2024/0077

46 Dodworth Road, Barnsley, S70 6EB

Conversion of loft to provide additional living accommodation with front dormer.

PROPOSED FRONT ELEVATION
SCALE 1:100 AT A3

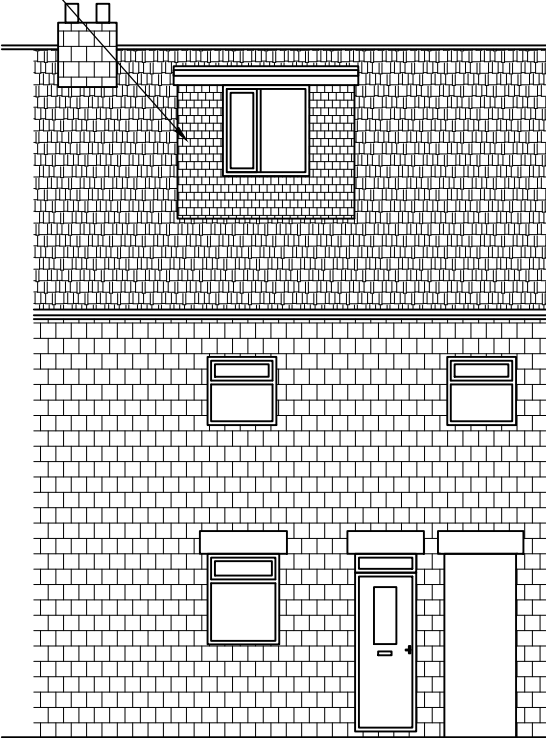
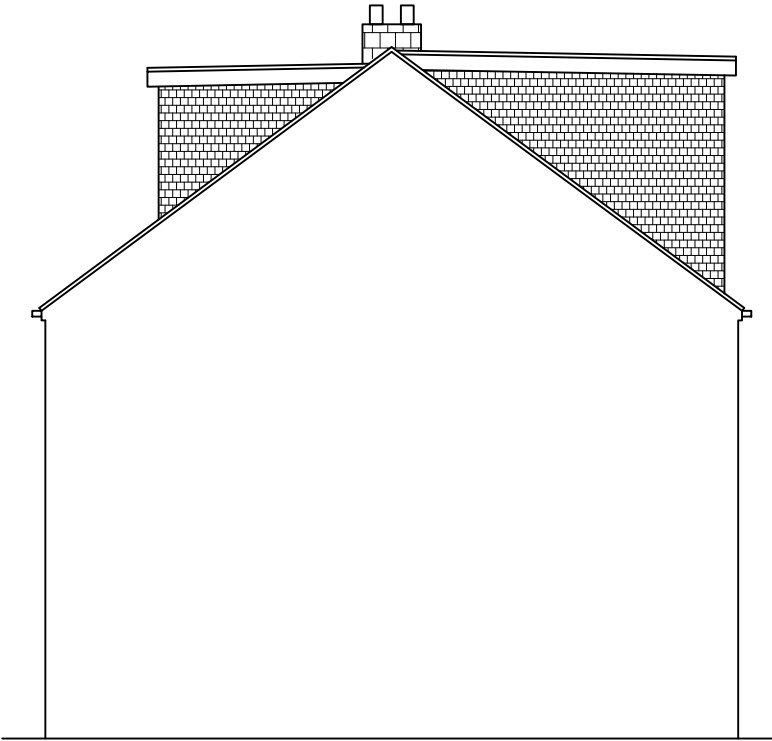
The proposed dormer window would have a total projection of approximately 2.5 metres with a width of approximately 2.3 metres and would have a total height of approximately 2 metres. The proposed dormer window would be constructed of materials that would match or be similar in appearance to those used in the external construction of the existing dwelling.

The proposed dormer window on the frontage of the application dwelling would adopt a flat roof. Flat roof dormers tend to be larger with a horizontal emphasis and have proved to be more expensive to maintain and prone to failure. Flat roof dormers are therefore considered to be aesthetically inferior and are not normally acceptable. However, in this instance, there are existing examples of flat roof dormer windows on the frontage within the locality and would therefore not be out of character for the area. The proposed dormer window would sit within the roof plane and the top of the dormer would be set below the ridge of the existing roof, the dormer window would be set back from the eaves and set away from the party walls with adjoining properties, and would be constructed of materials that would closely match those used in the exterior construction of the existing dwelling, in accordance with the House Extensions and Other Domestic Alterations SPD.

Whilst a pitched roof would have been more desirable, the proposal has been amended to set the dormer window below the ridge of the existing roof as not to disrupt the existing ridge line and to maintain its significance. Overall, the proposal would be a modest addition incorporating sympathetic elements and adopting a form that would not be out of character for the area.
